MAJOR PROJECT APPLICATION: MP 06_0205
Modification No 2

Response to Shoalhaven City Council Interim Submission

MASTER CONCEPT PLAN
SCALE: 1:1000 @ A1, 1:2000 @ A3

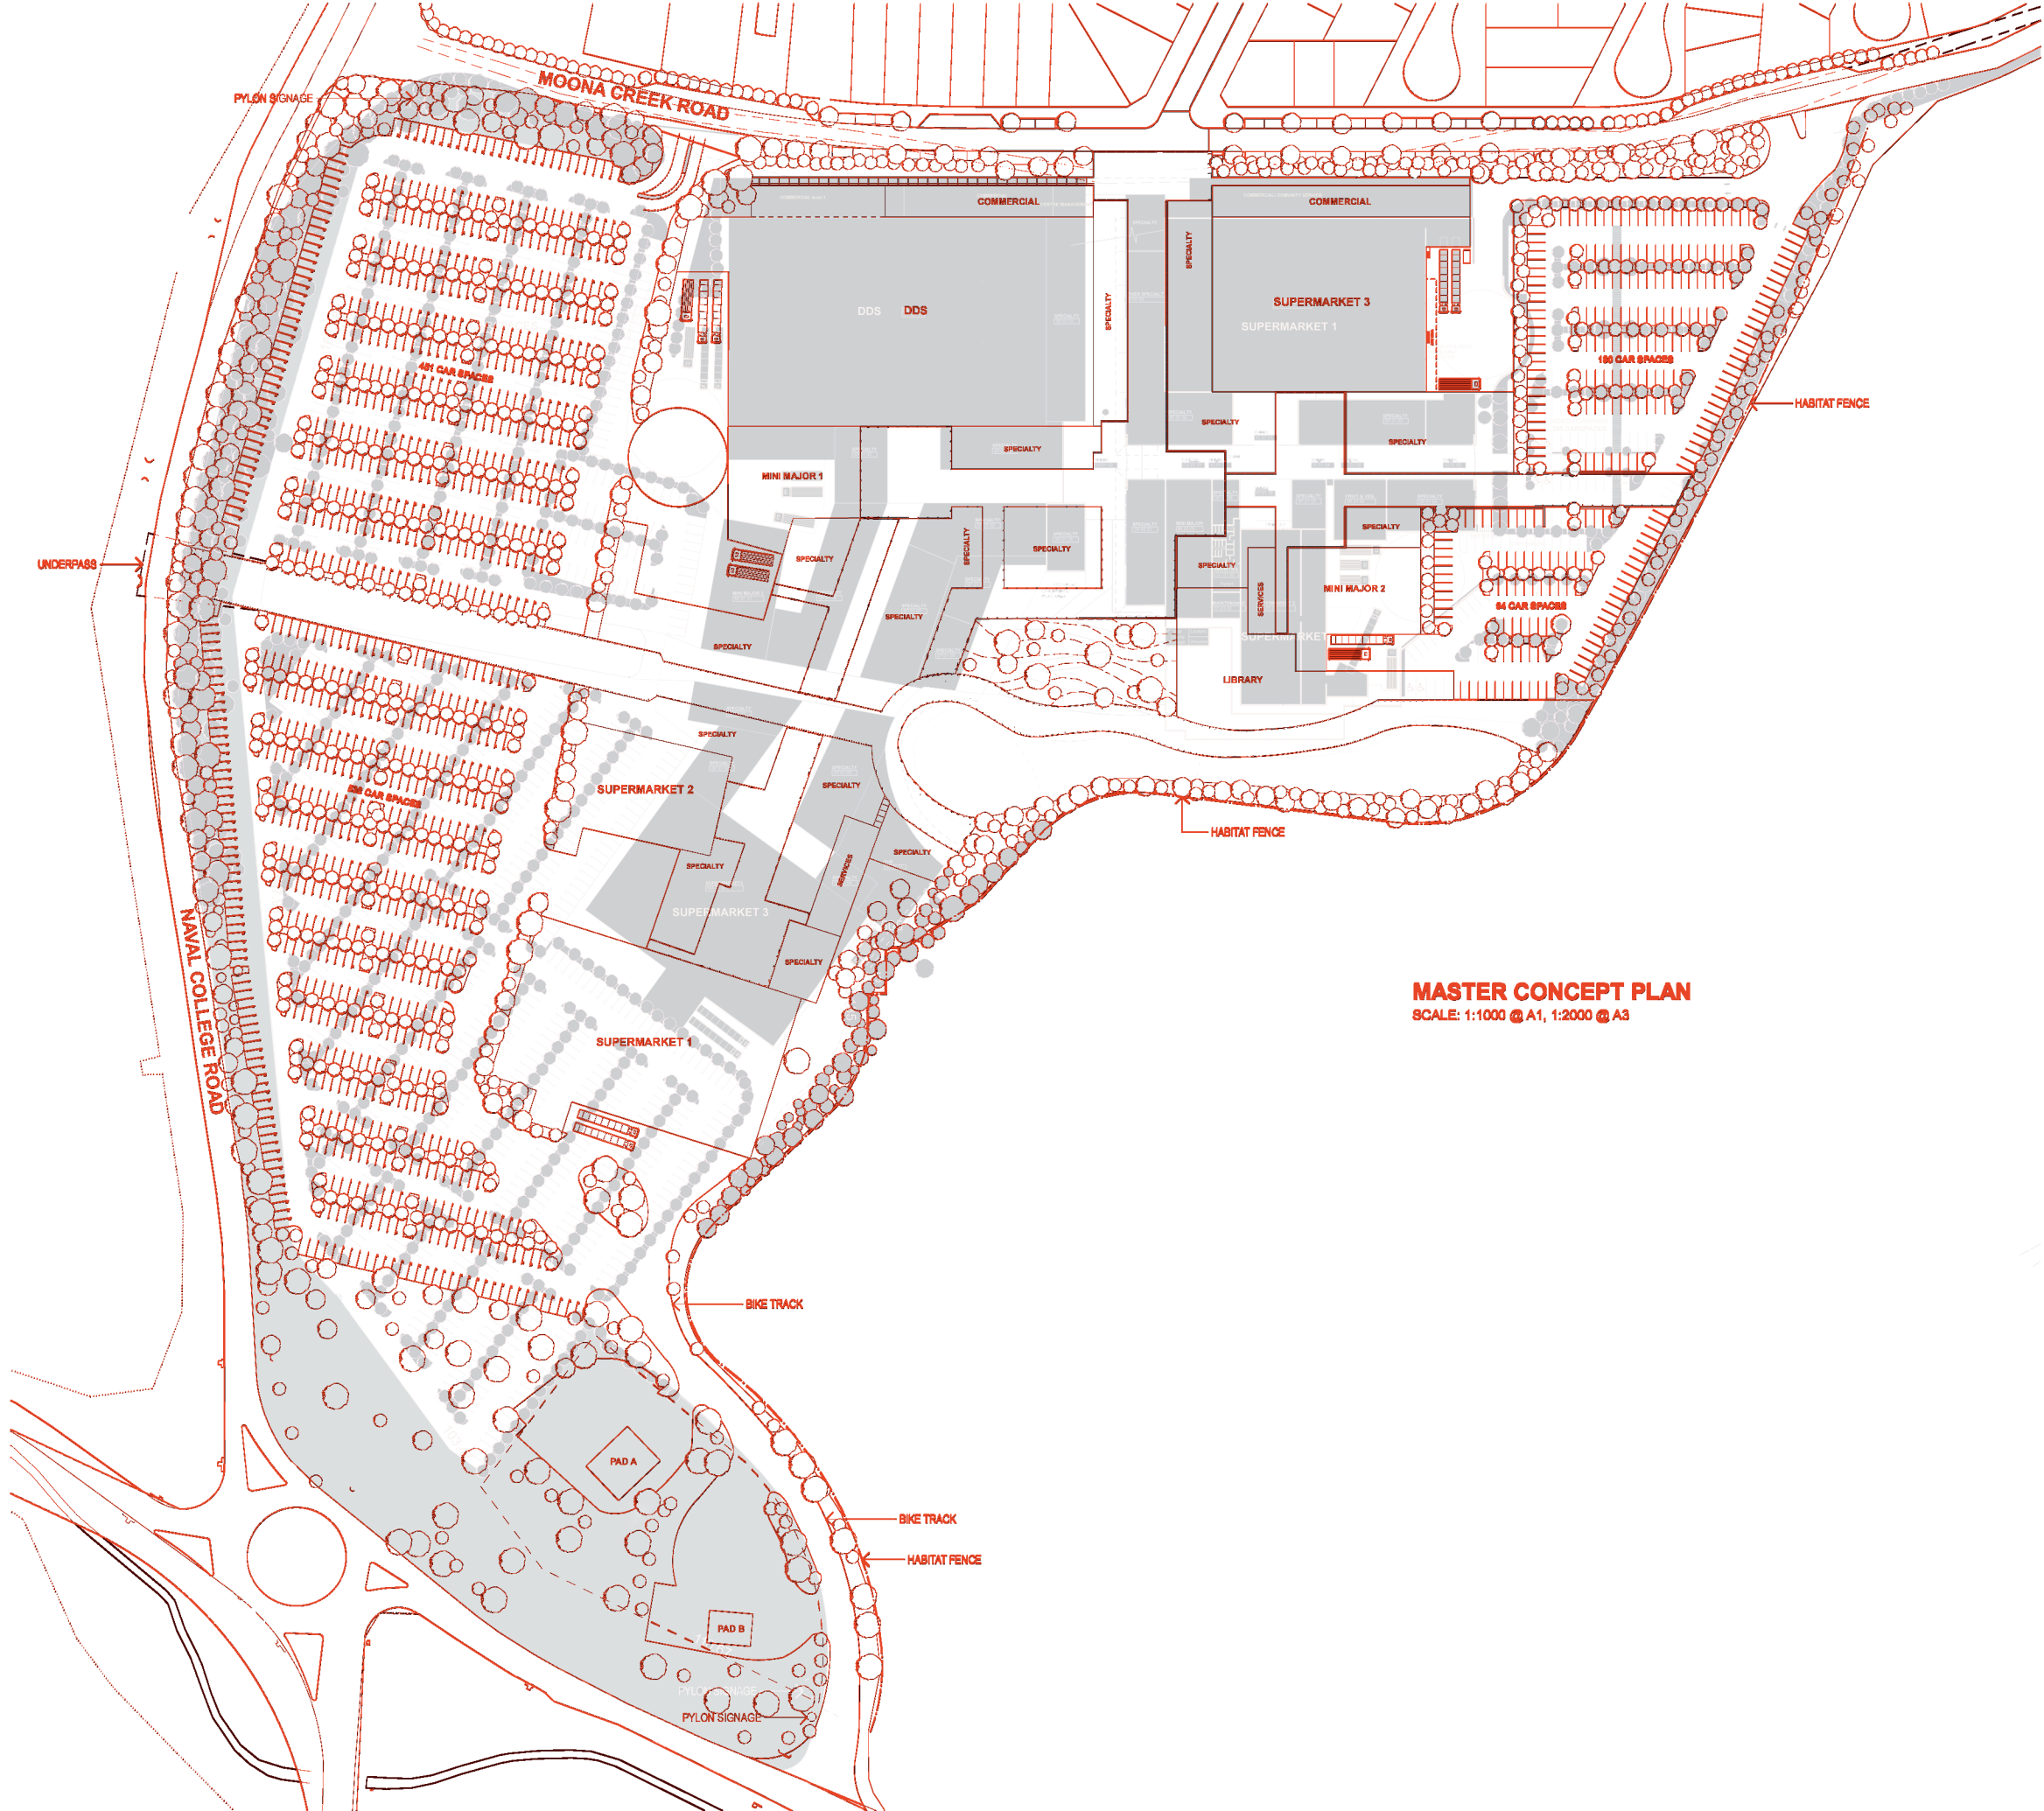
i) *There is no screen planting shown adjacent to the 2nd stage car park. This is not acceptable on this prominent corner of the development. It is unclear if the existing buffer is to be removed or retained.*
Site Image Response: All existing bushland in this area is to be retained and protected where possible to accommodate the development works. This existing bushland forms part of this buffer with additional buffer planting being installed where appropriate to reinforce the buffer.
